RE: M23-D018, LOPEZ/MONTOYA RESIDENCE
TO: CITY OF ALBUQUERQUE, HYDROLOGY
MR. GREG OLSEN, P.E.
FROM: WESTERN CIVIL
BROOKE M. GARCIA, P.E.
DATE: DECEMBER 16, 2013

Response to City Comments (letter and mark-ups dated 11-19-2013):

GRADING PLAN

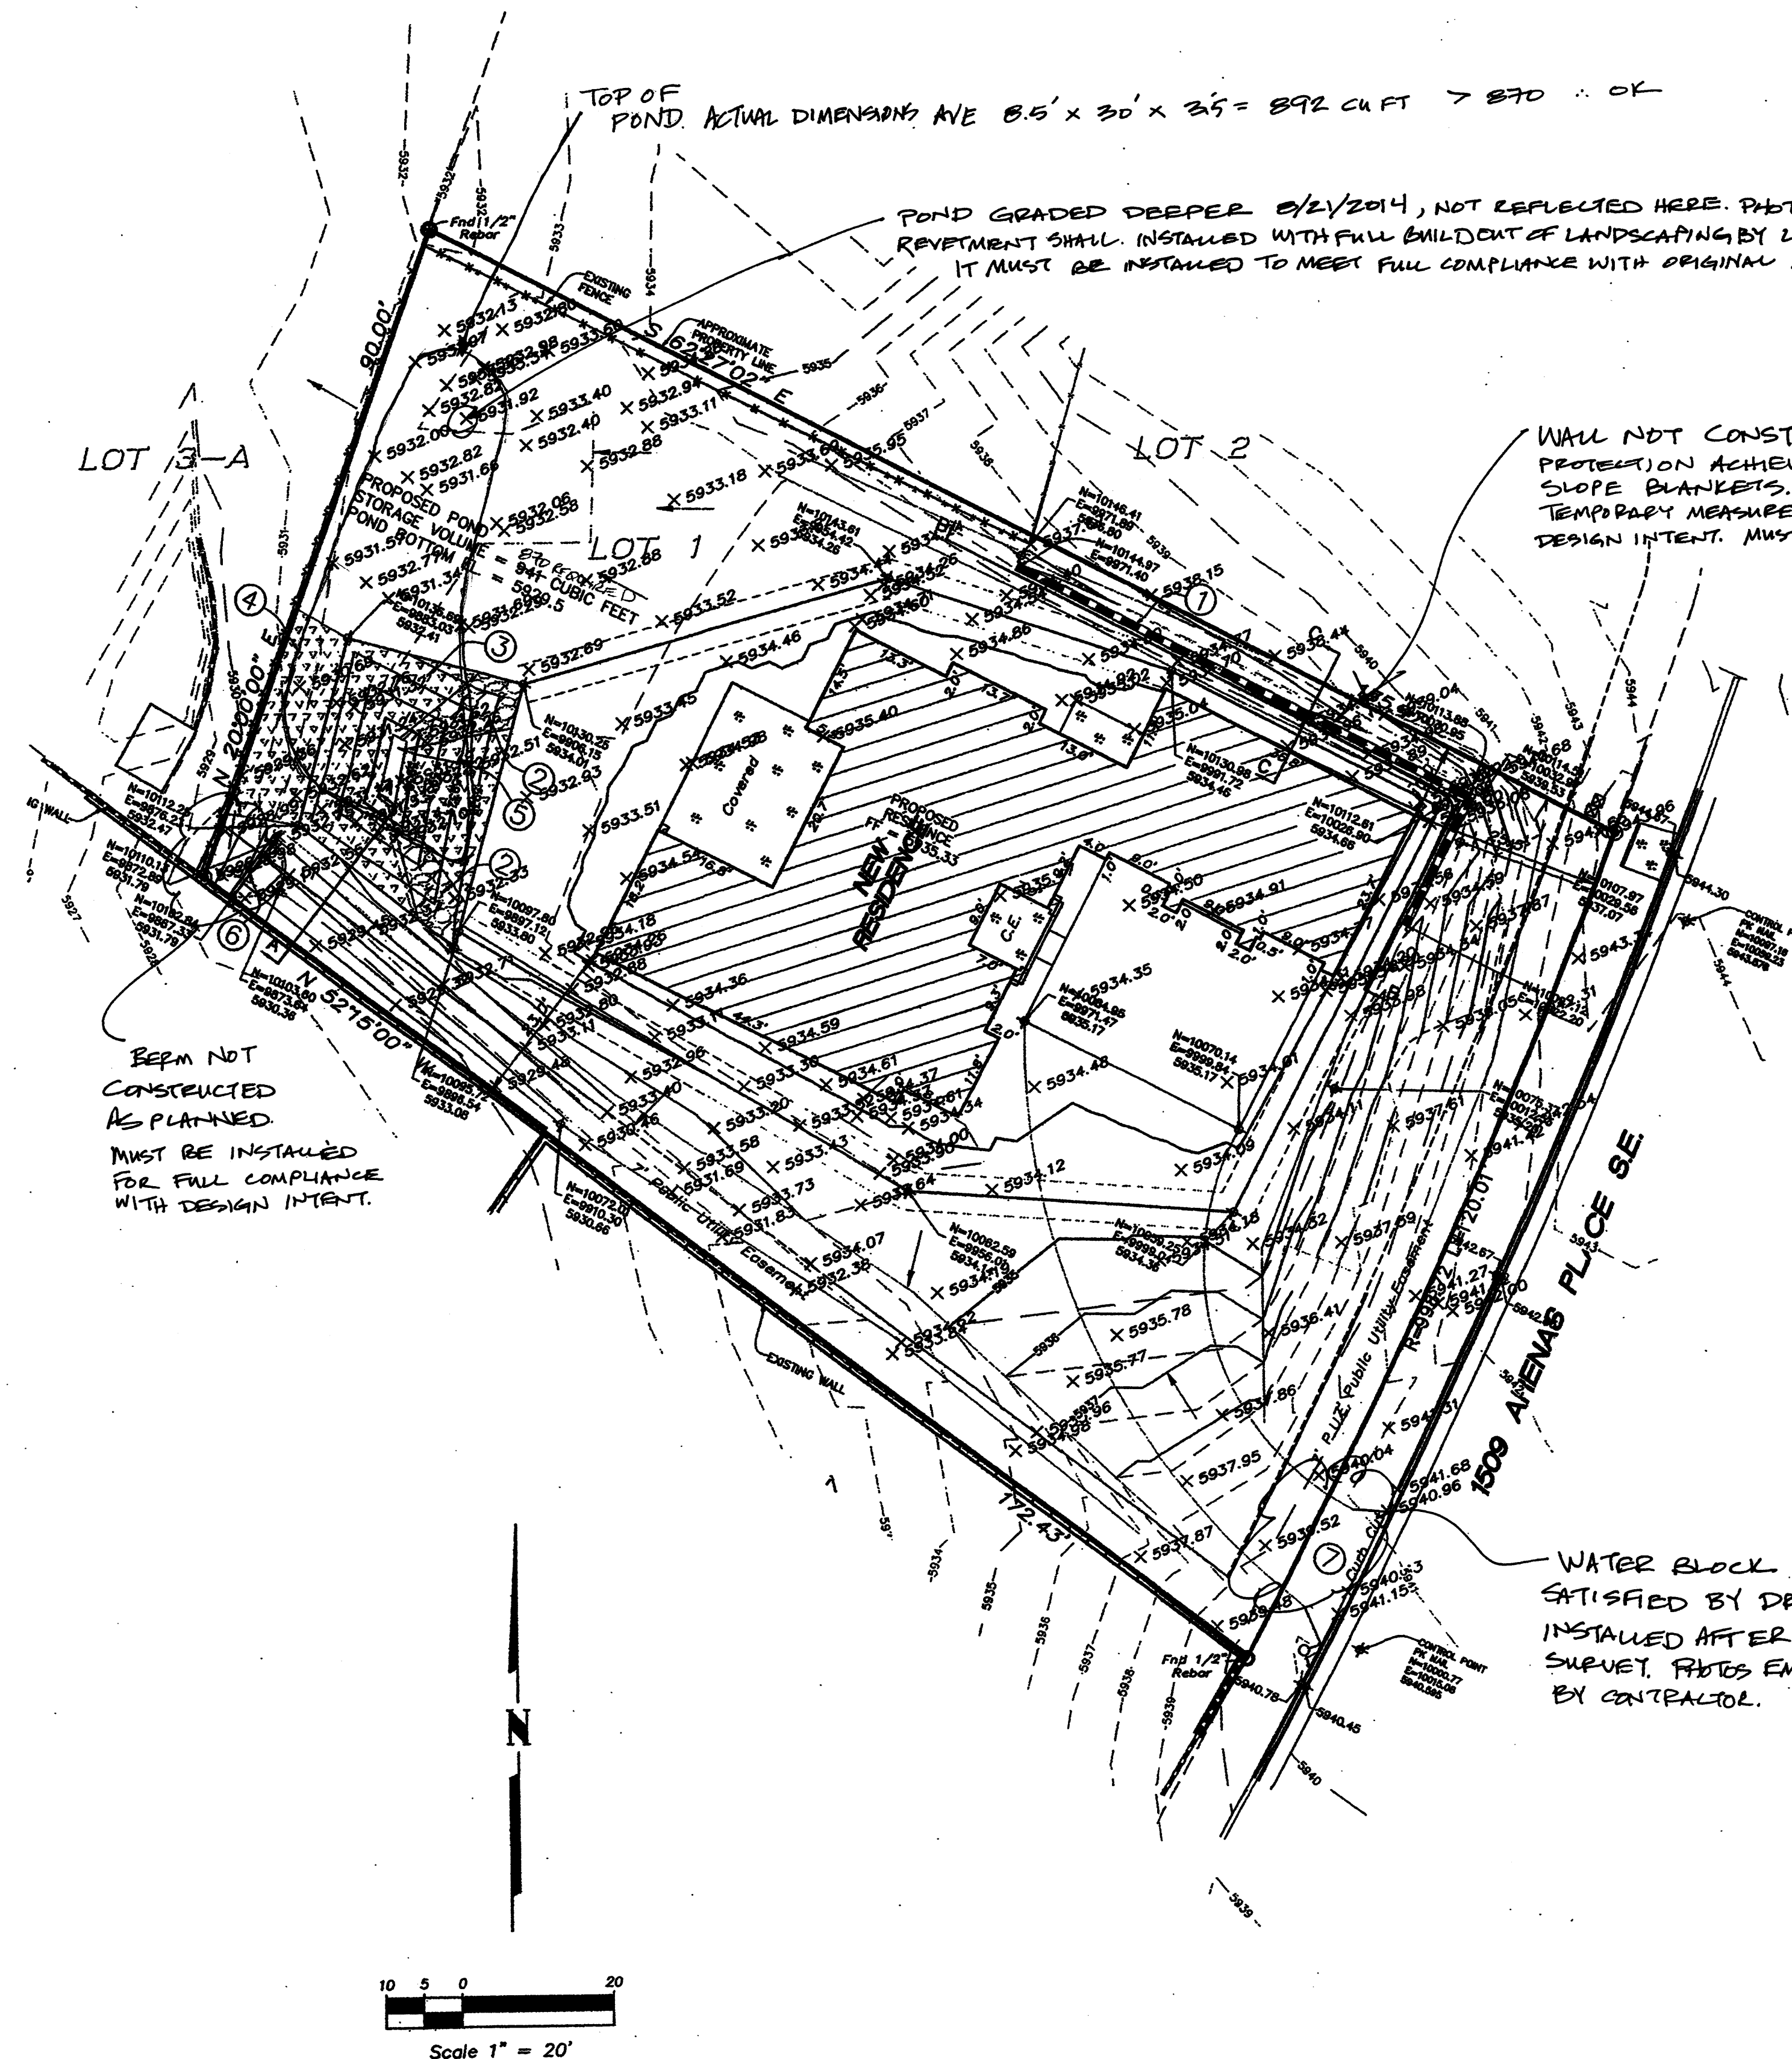
1. a-d. See Attachment F.; e. See page one of this memo for Vicinity Map. Flood Map included in Attachments.
2. Historic and Proposed drainage basins shown on attached basin map. Hydrology calcs attached. Pre- and post-design flows shown on Grading Plan.
3. 12" water block called out on Grading Plan.
4. Survey shows wall.
5. Spot elevations included as needed on Grading Plan.
6. Site slopes are limited to 3:1 everywhere. Erosion is designed in accordance with the DPM and City Specs. A wall has been included at the NE corner of the property to prevent installation of slopes steeper than recommended in the DPM.
7. Flow calculations included.
8. Easement drainage along southern border of the property limited to 18" rise along existing wall.
